Your Ref: OWPC15519
Our Ref: R/184/17/PD 08-08-2017
Please ask for:
Mrs A Gardner

Notification for prior approval under class C for a change of use from a shop (Class A1)
to a restaurant/cafe (Class A3)
51 Sea Lane Rustington

**APPENDIX ONE:
DRAWING SHOWING EXTERNAL EXTRACT AND VENTILATION EQUIPMENT PROPOSED**

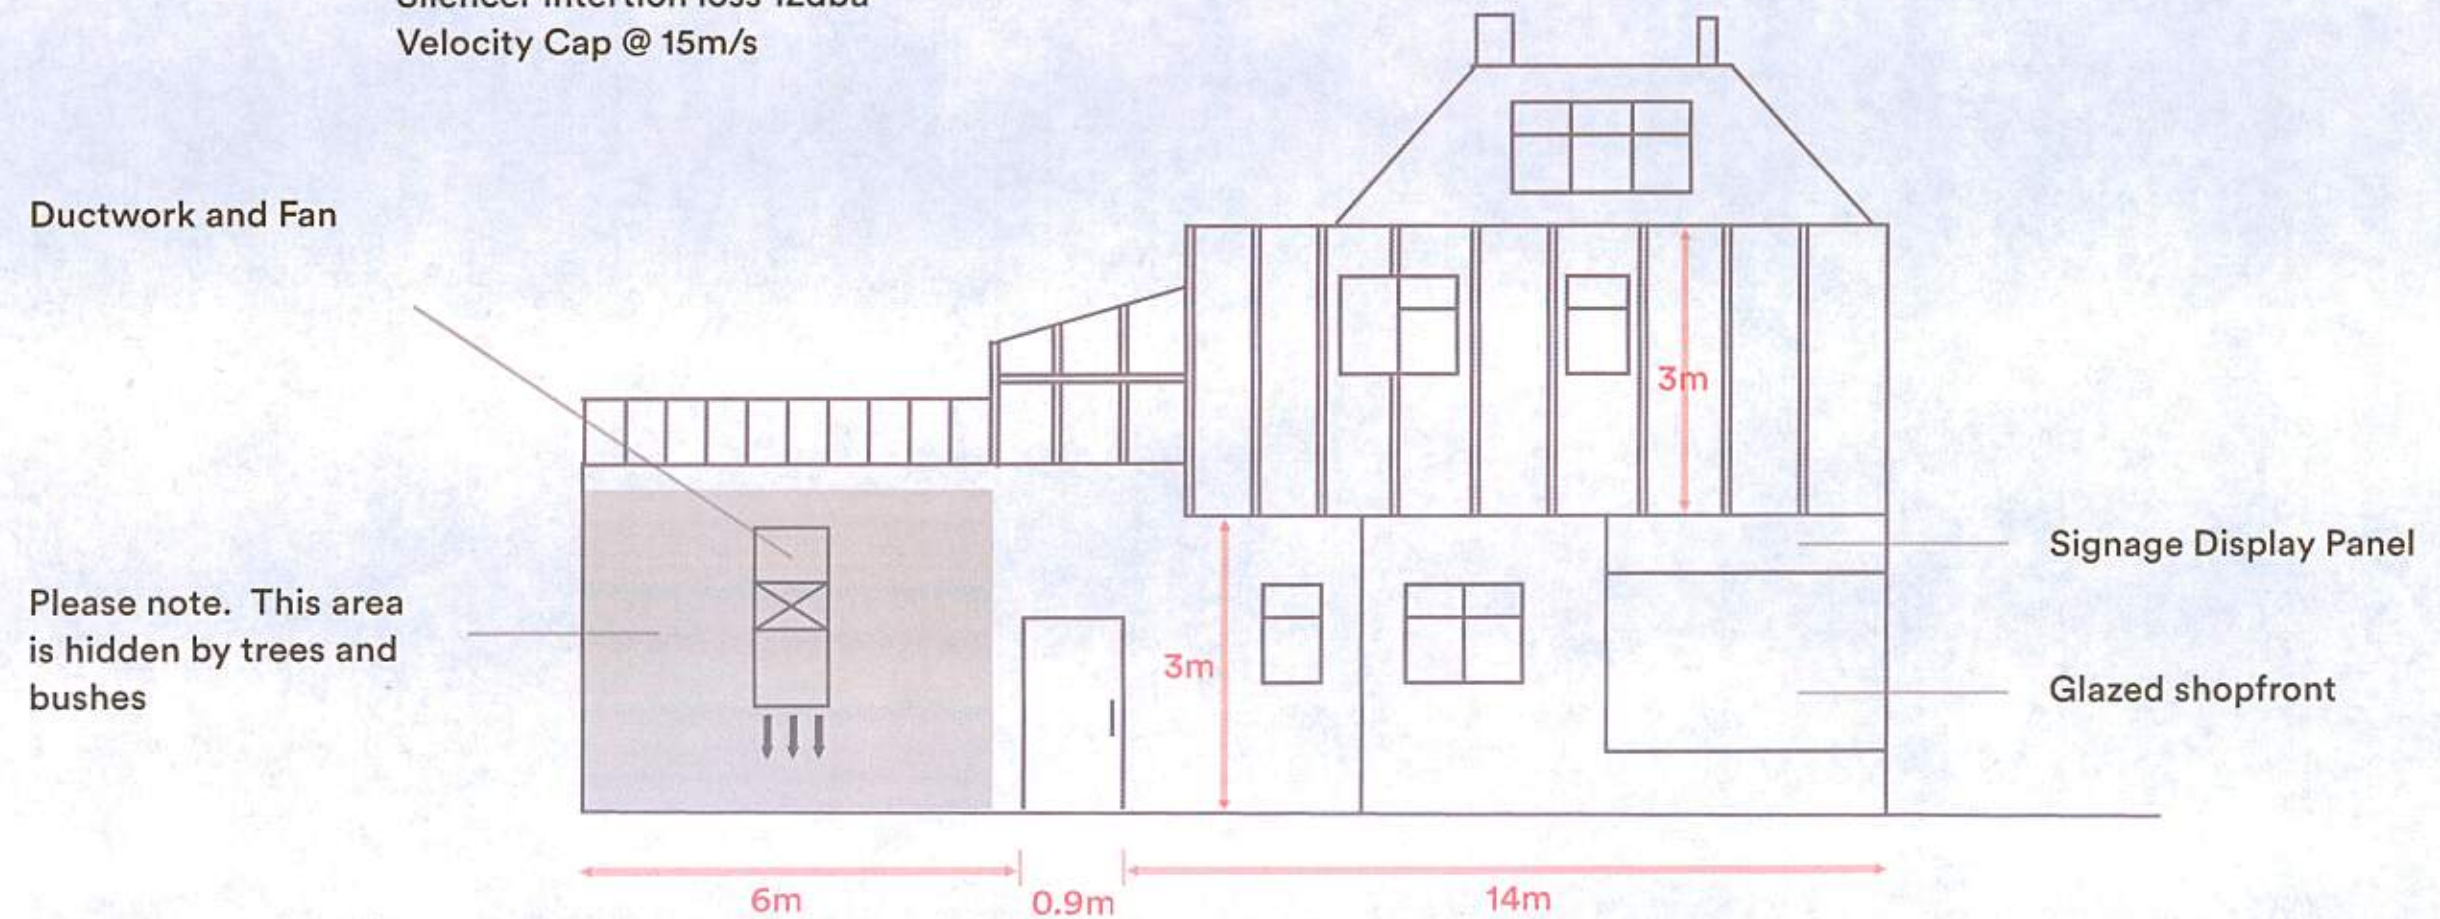
Proposed plans show a large ventilation duct from the proposed kitchen, which will cause noise and smells.

APPENDIX TWO:
DRAWING SHOWING PROPOSED REFUSE FACILITIES

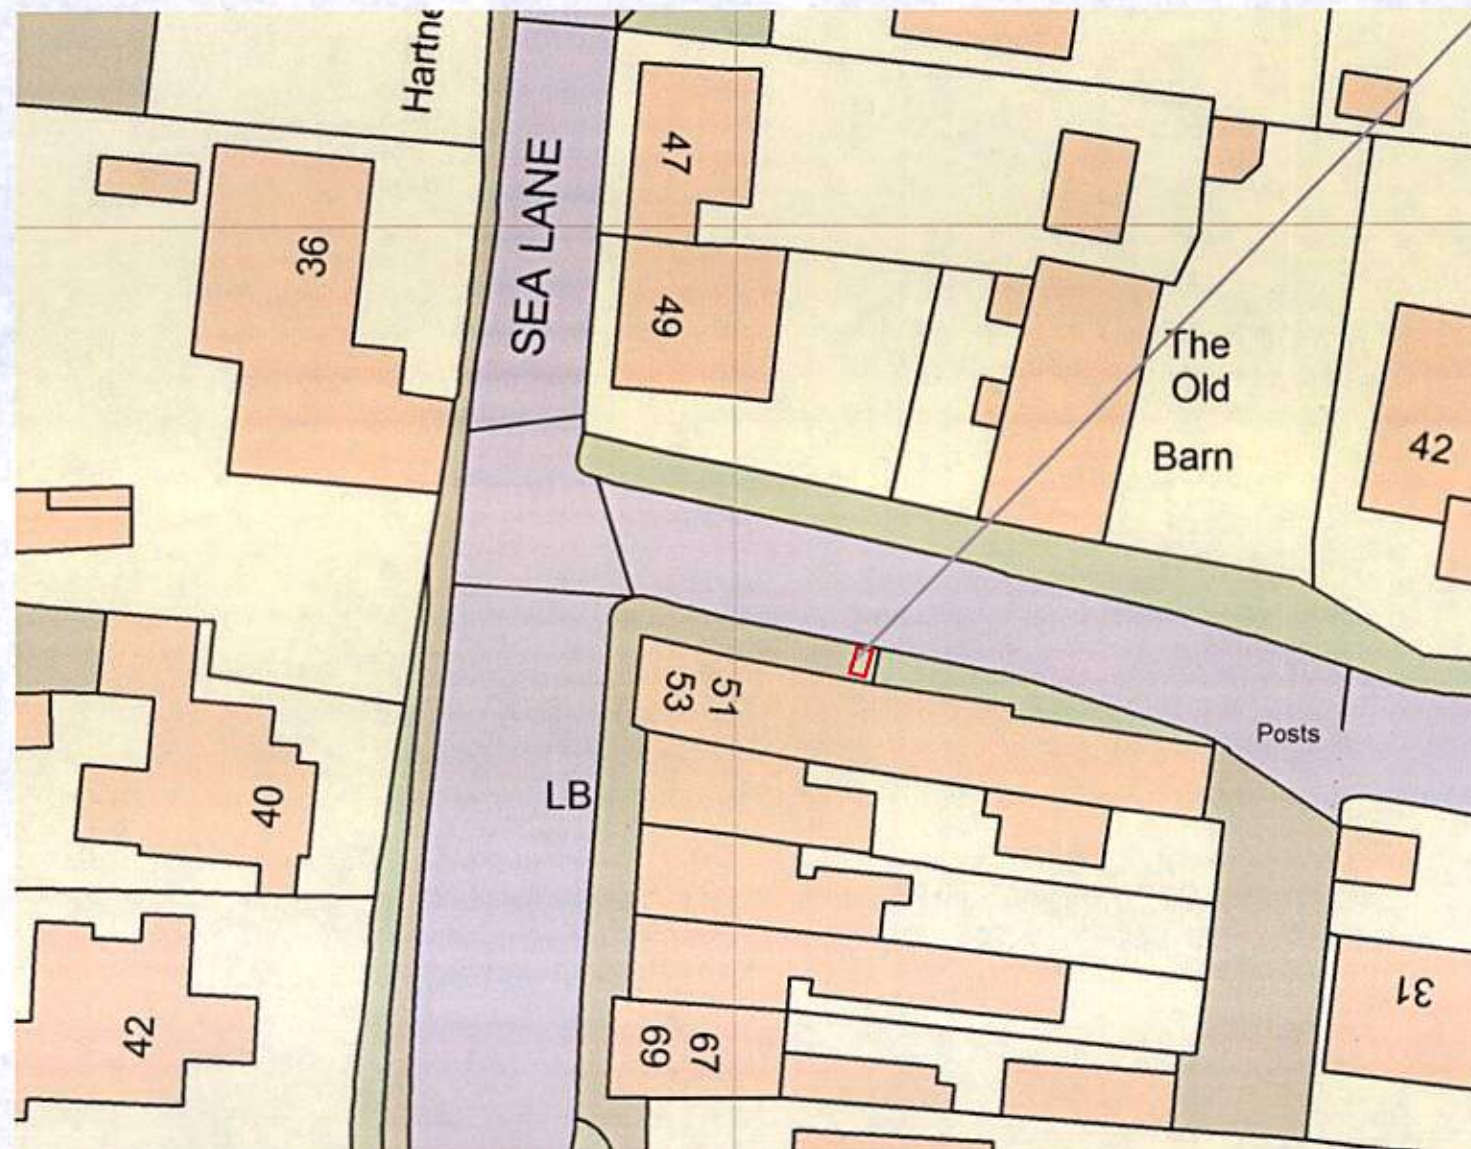
The plans show a wooden bin storage unit,(no dimensions are given),containing two 'large' bins for food waste. This will further increase the vermin problem we have in the area.
